Appendix A – Response to Wollongong City Council Submission

A detailed response to the matters raised in the submission of Wollongong City Council (**Council**) is provided in the table below.

3.2 Street Trees Locations in Stage 2-4

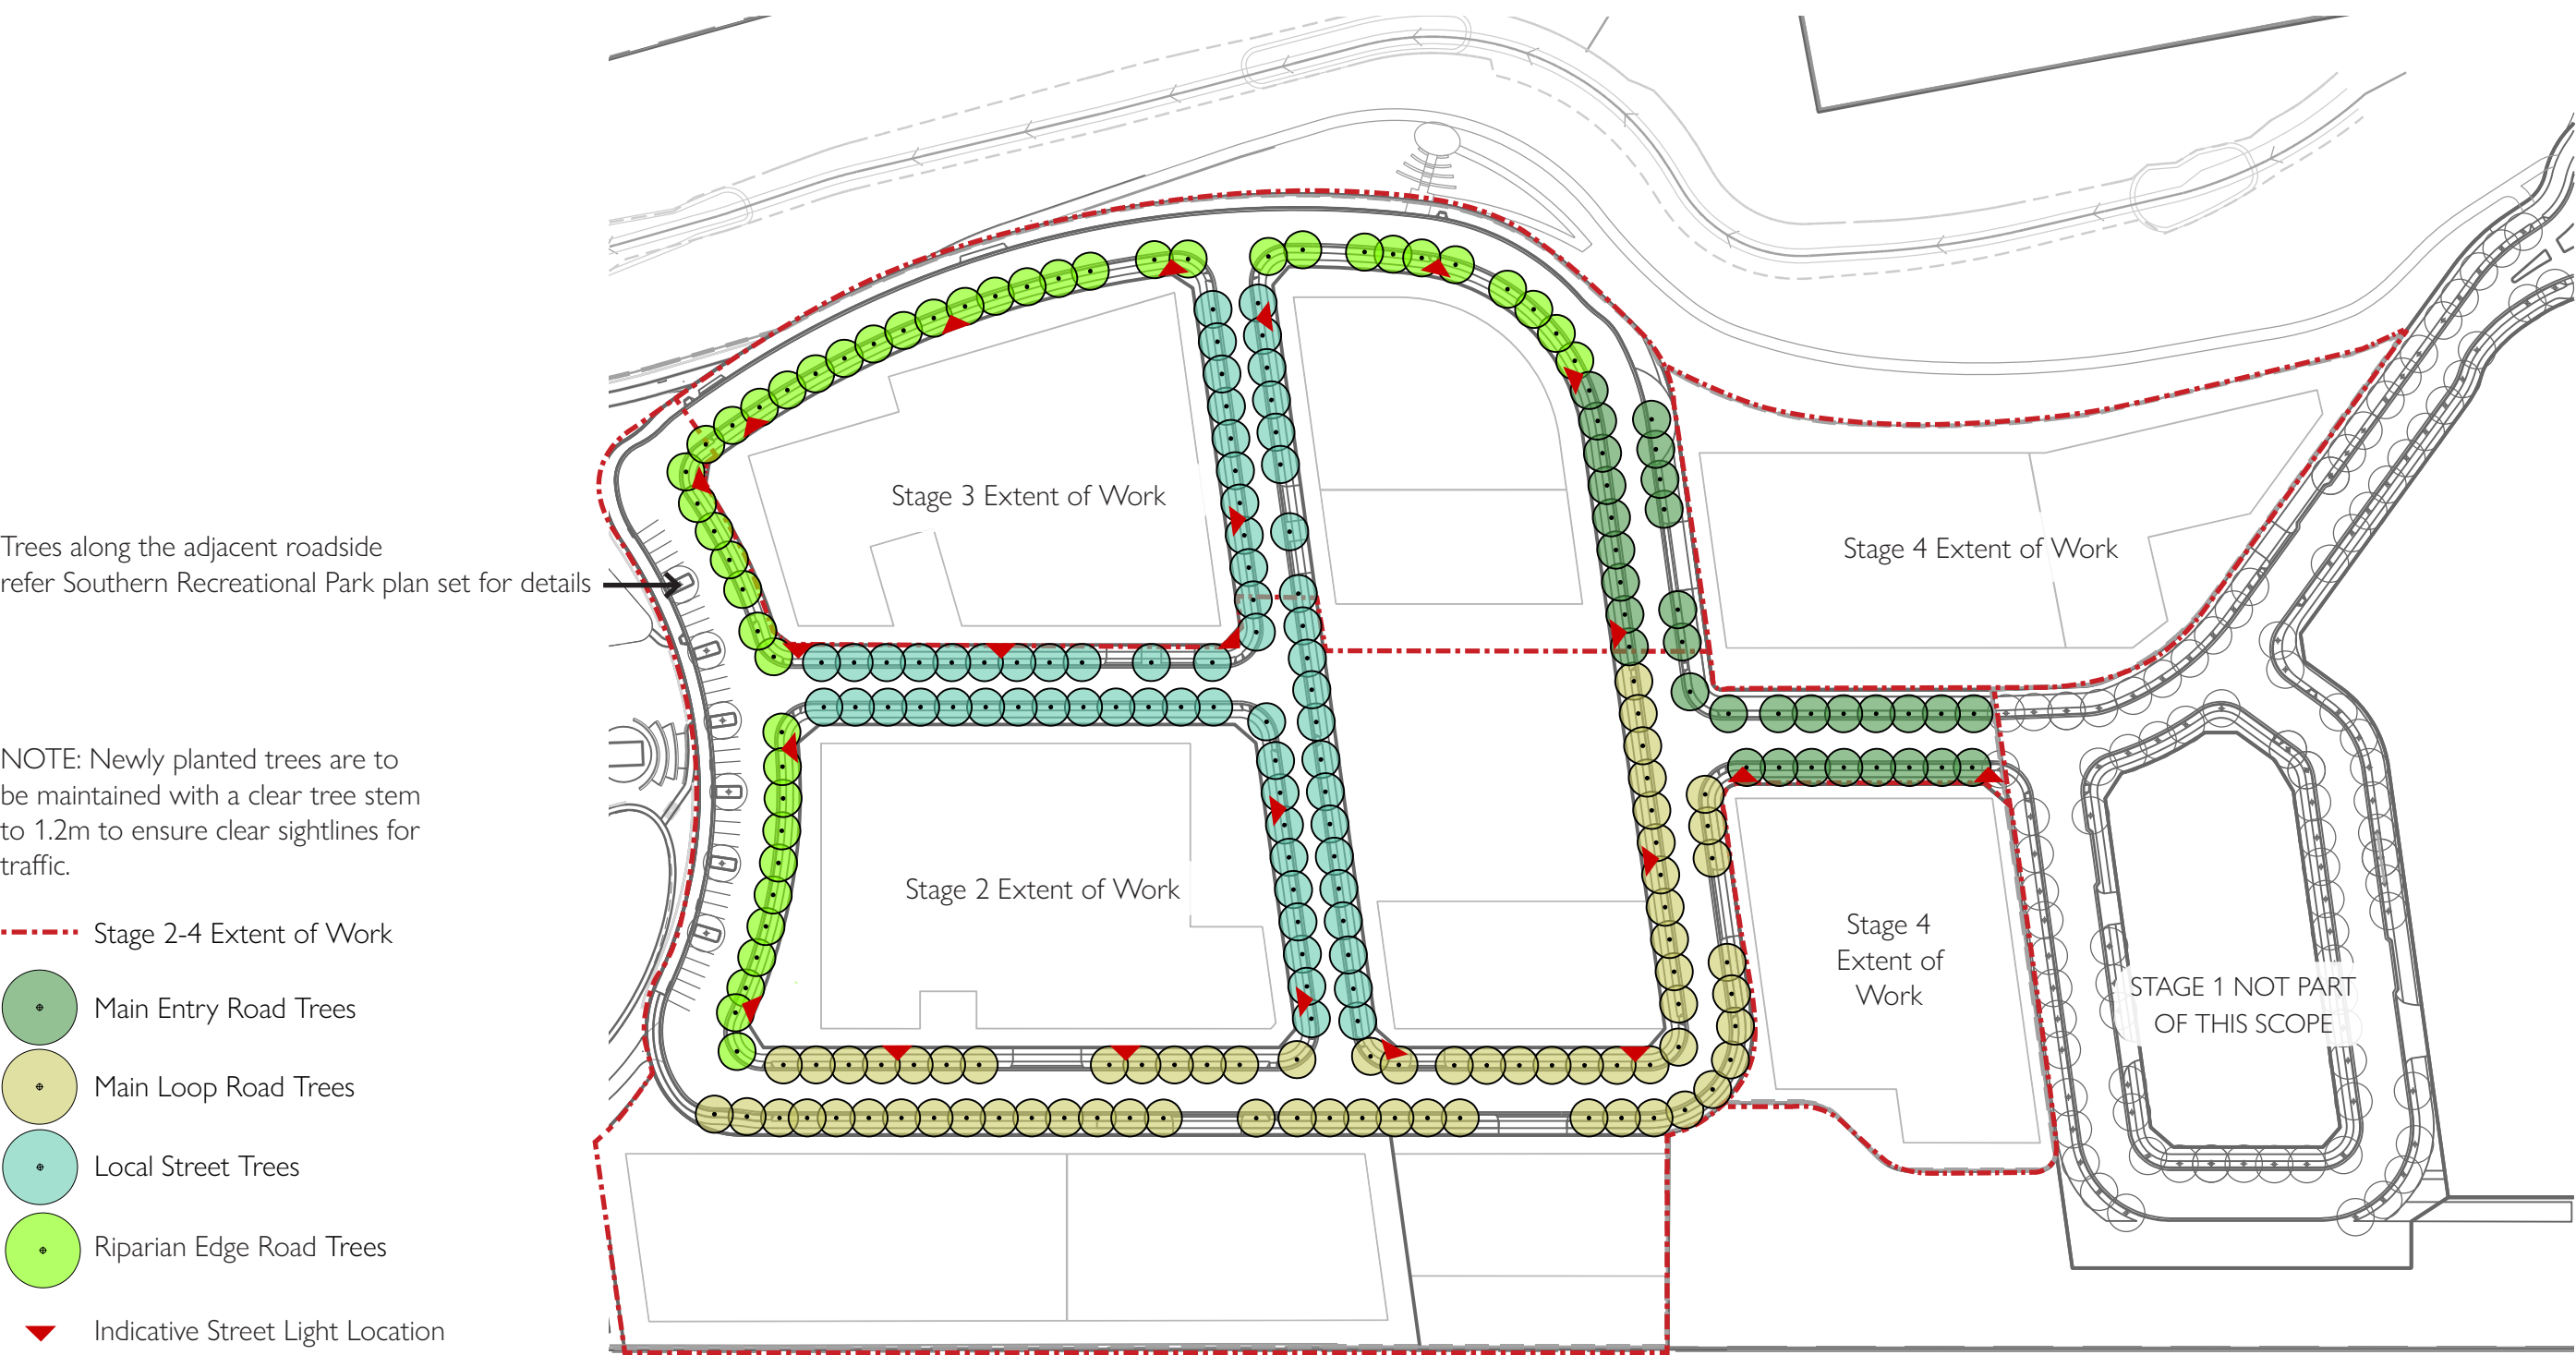
- The proposed street-tree planting layout does not comply with Council's minimum clearance requirements. Several trees are shown in conflict with driveways, intersections, streetlights, utilities and other public domain infrastructure.
- The Landscape plan requires amendment to demonstrate the following mandatory minimum clearances are met:

- 10 m from intersection kerb line
 - 5 m from centre of pole
 - 2 m from edge of inlet
 - 3 m from edge of junction box
 - No trees along length of stop
 - 4 m from vehicle crossing
- The revised layout must demonstrate full compliance with Council's street-tree planting standards.
 - The proposed locations of proposed soil vaults must be clearly indicate on the plans.

- Multiple proposed street-tree locations conflict with stormwater pits, pipes, service routes and underground infrastructure. The landscape plan must be amended to ensure all proposed trees are located clear of stormwater assets and underground services.

- Tree locations must be coordinated with the civil engineering plans to avoid structural conflicts, asset damage and future maintenance constraints.

- In relation to street tree clearances, and conflicts with stormwater infrastructure, Clouston Associates have revised the Landscape Design Package for the Stage 2-4 Streetscape. The revised package adjusts the tree planting layout to ensure that the street tree planting is compliant with the clearance zones. Additionally, the revised layout resolves the tree locations in conflict with the stormwater infrastructure.
- The utilities in relation to this SSDA are preliminary and subject to the relevant approval and detailed design process post determination. Further

detailed design refinements including tree locations can be resolved post determination via reasonable and relevant conditions of consent.

These revisions have been updated across the landscape design package and civil engineering plans.
